RE: **Warehouse, 4455 Anaheim  
Grading and Drainage Plan  
Engineer's Stamp Date 6-11-2015 (File: C17-D123)**

RE: **Warehouse, 4455 Anaheim**  
**Grading and Drainage Plan**  
**Engineer's Stamp Date 5-13-2015 (File: C17-D123)**

**DRAINAGE REPORT**

ENGINEER'S SEAL	4455 ANAHEIM	DRAWN BY WCWJ
	GRADING AND DRAINAGE PLAN	DATE 6-11-15
		21515-LAYOUT-5-03-15
DAVID SOULE P.E. #14522		SHEET #
		JOB # 21515

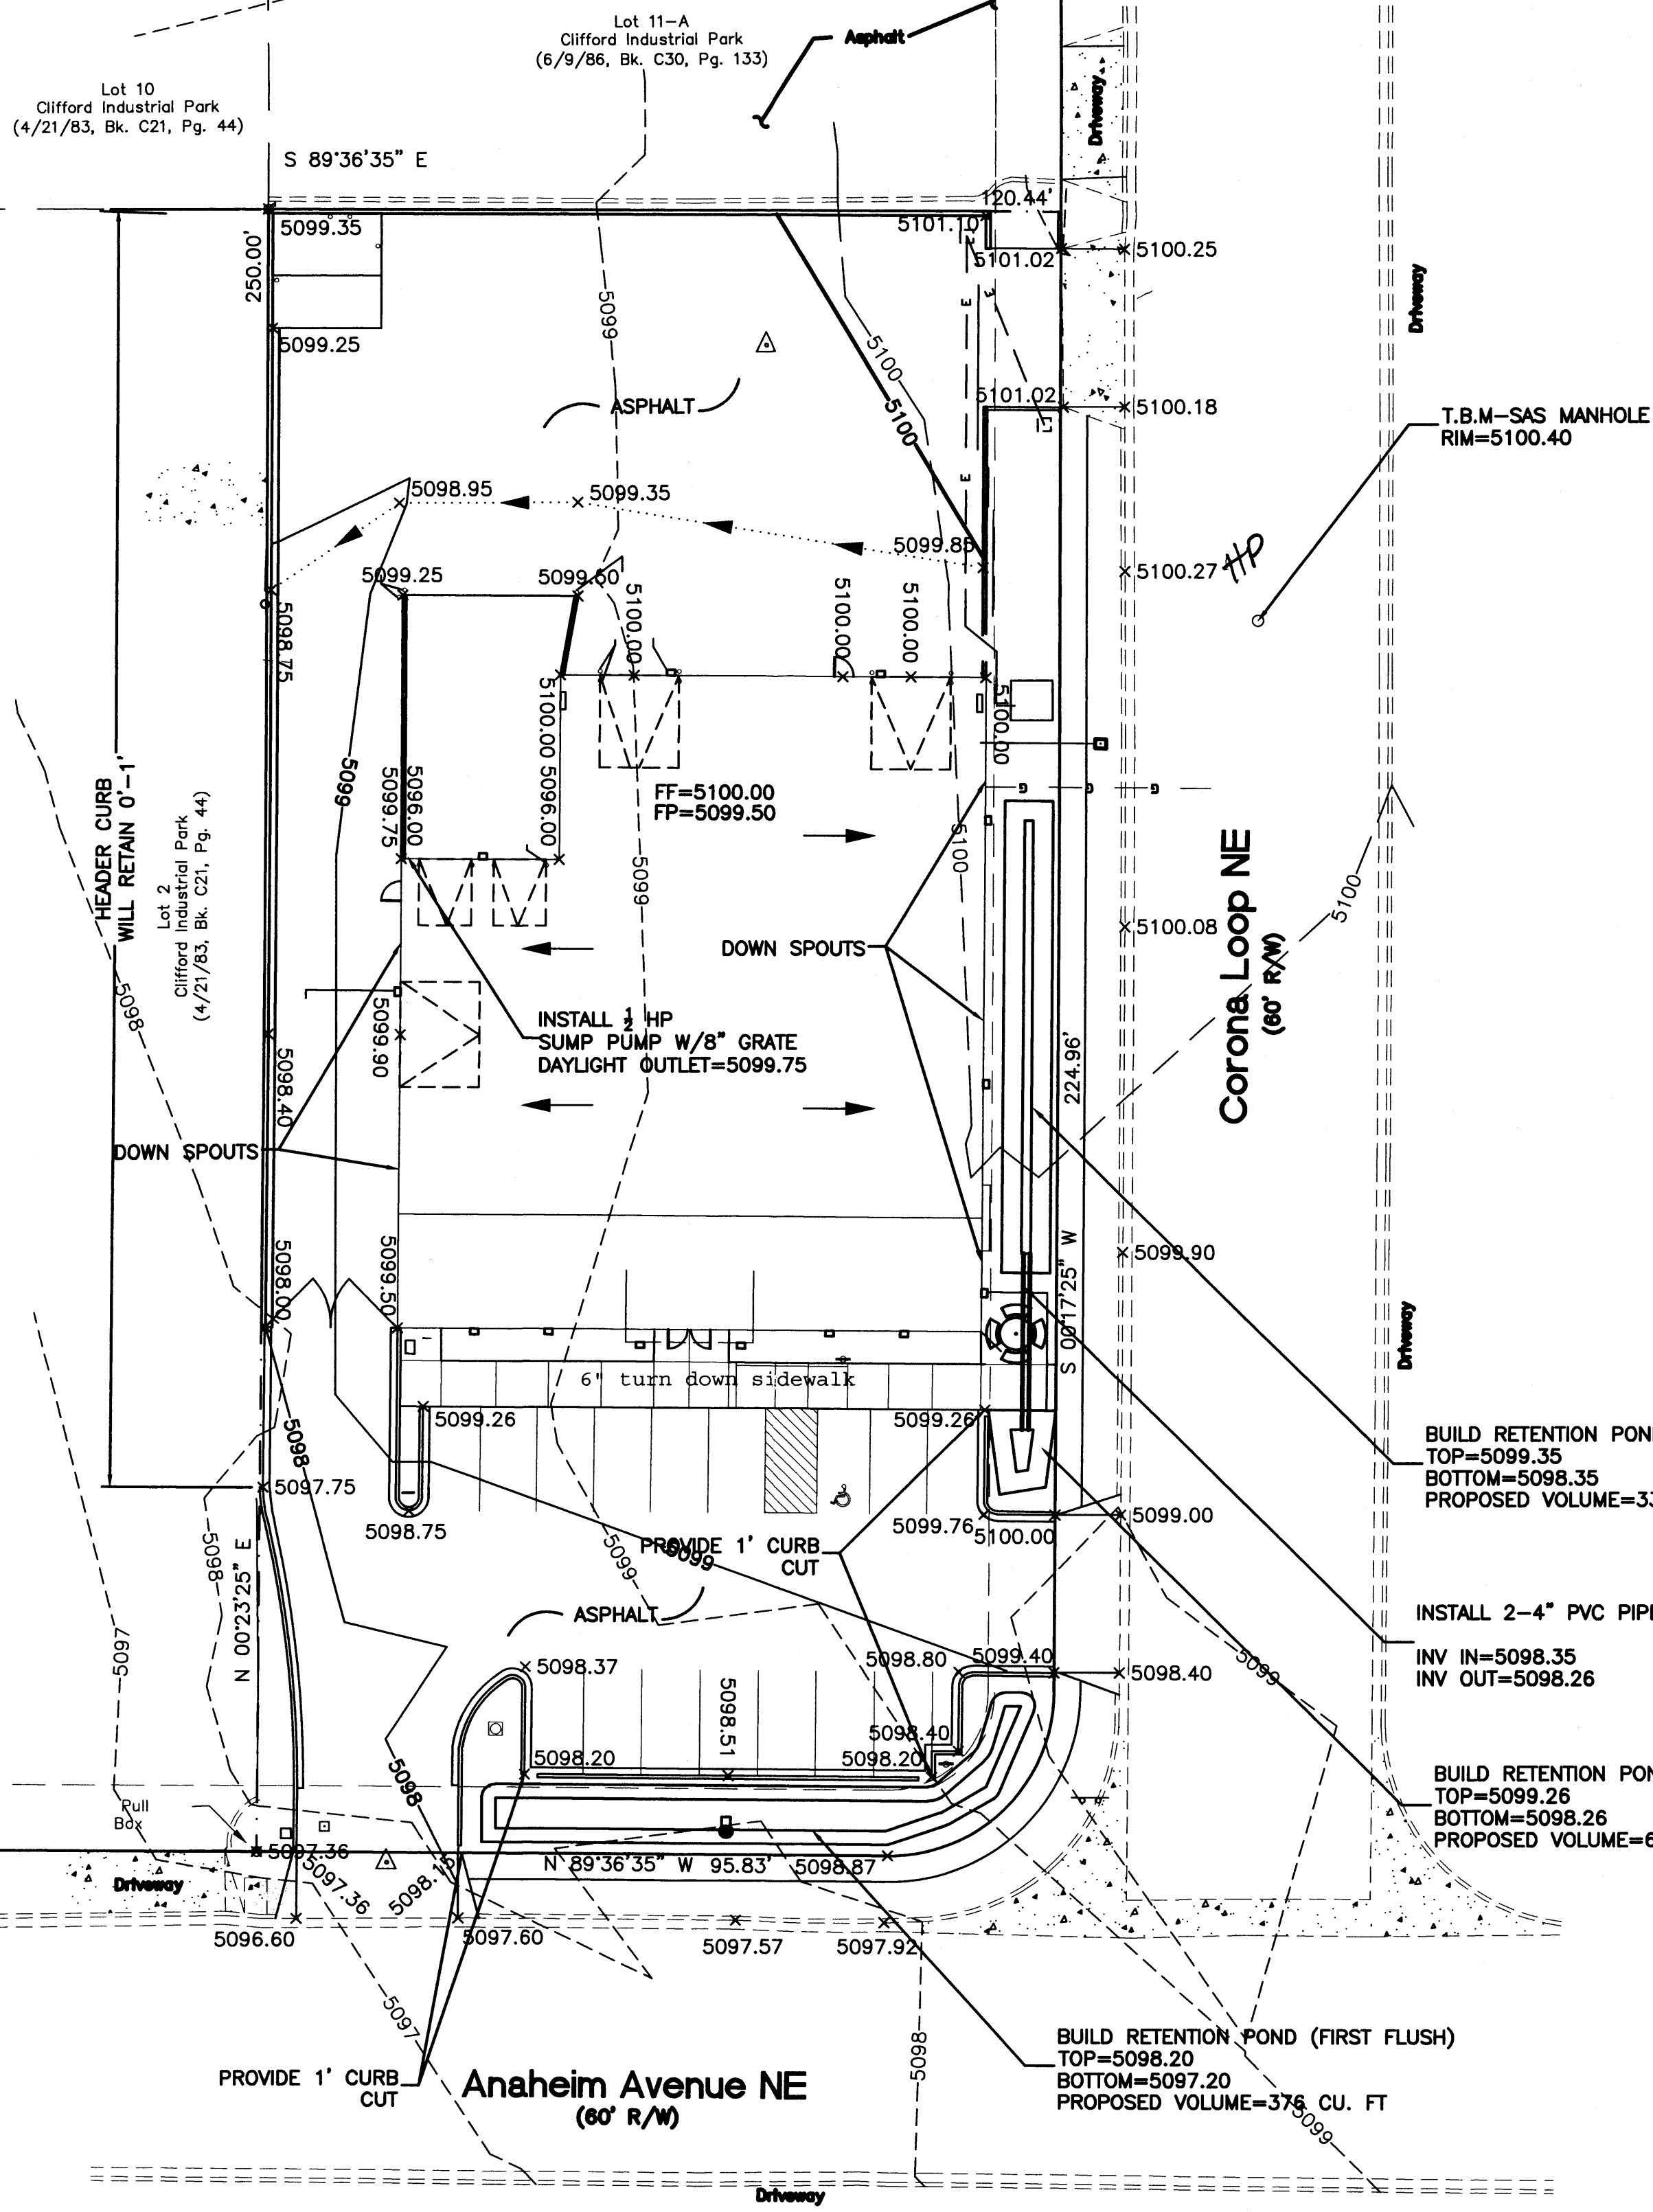
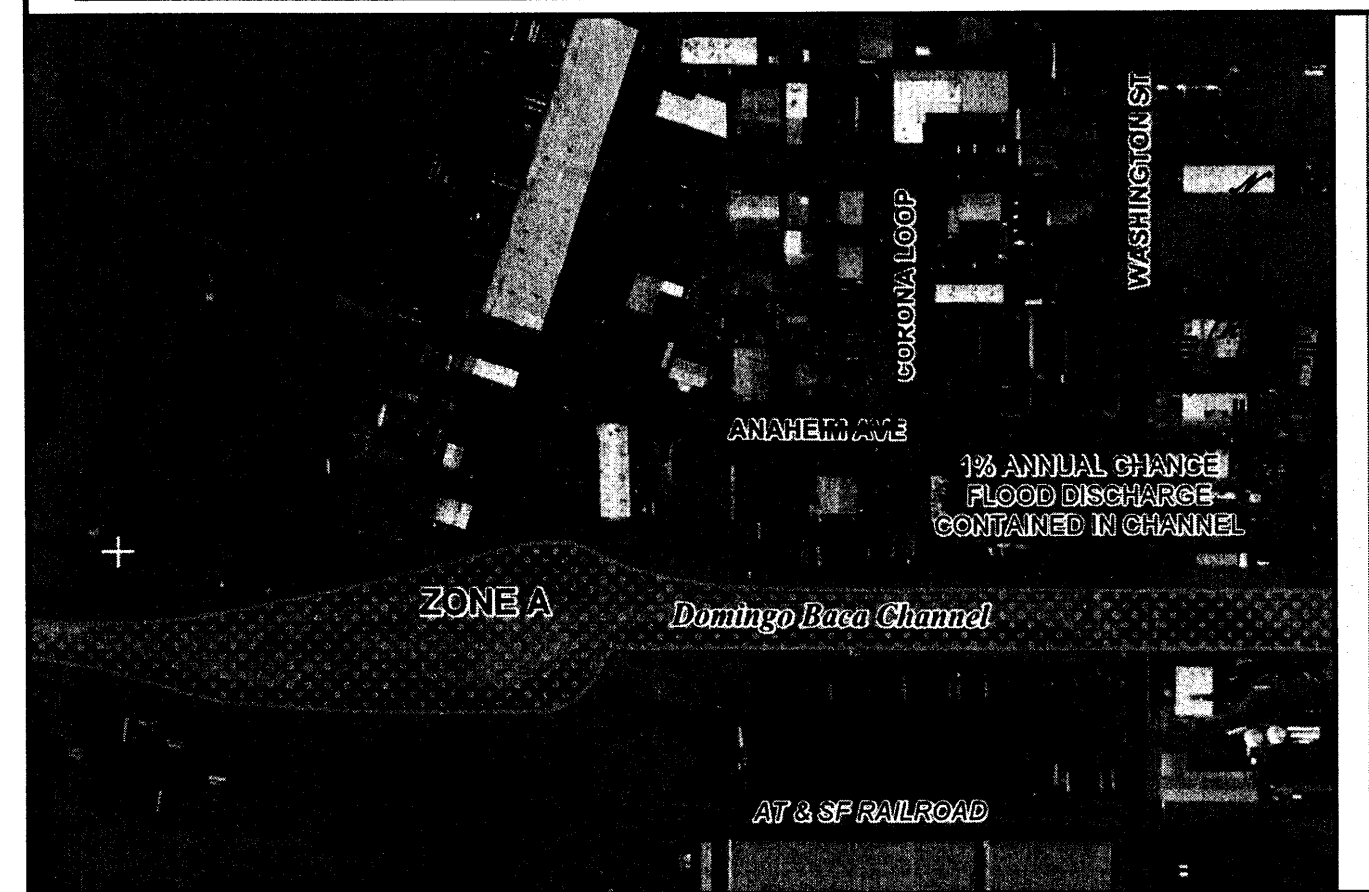
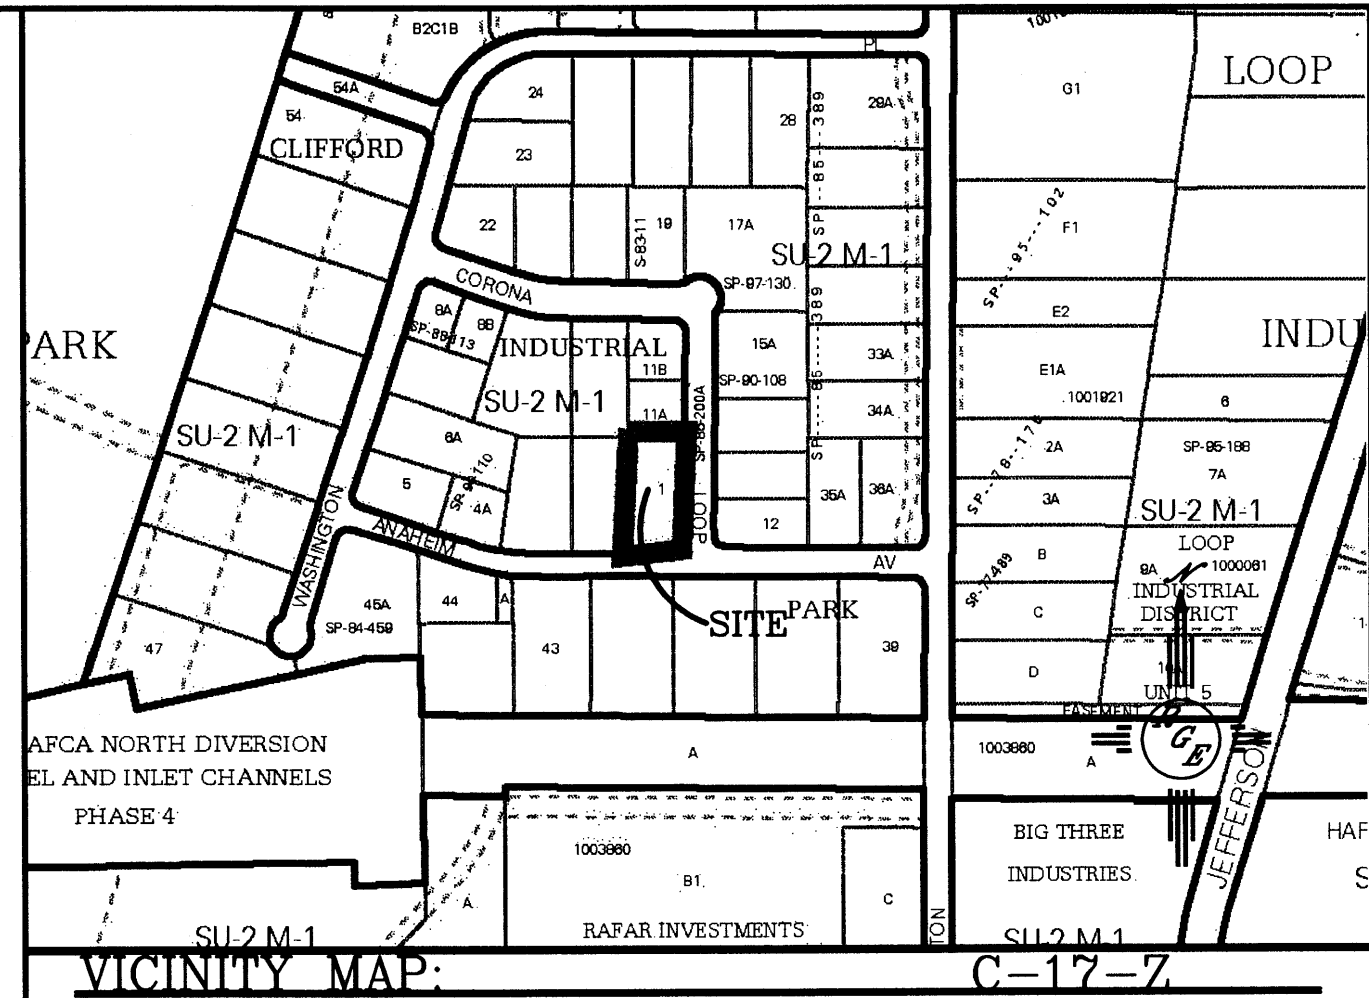
- 1) Provide new and existing curb linetypes and building boundary within legend. Label any gravel areas as "gravel" and paved areas as "paved", and count gravel lot areas as land treatment type "C". Label any new curb and curb height on the plan view as applicable. **We have label the apphalt and curbs**

- 2) Show roof drain locations. **We have added direction and downspouts**
- 3) Show existing spot elevations for curb on Corona Loop and on Anaheim Avenue. Label proposed contours, and additionally provide boundary lines around each of the pond areas that define the top and bottom elevations of the pond. For the three retention ponds, indicate that they are for the "first flush" if this is the case. If new spot elevations provided are at flowline of curb, provide general note stating this. **added spots. line tyoes. labeled ponds. note #1 states spots flowline**
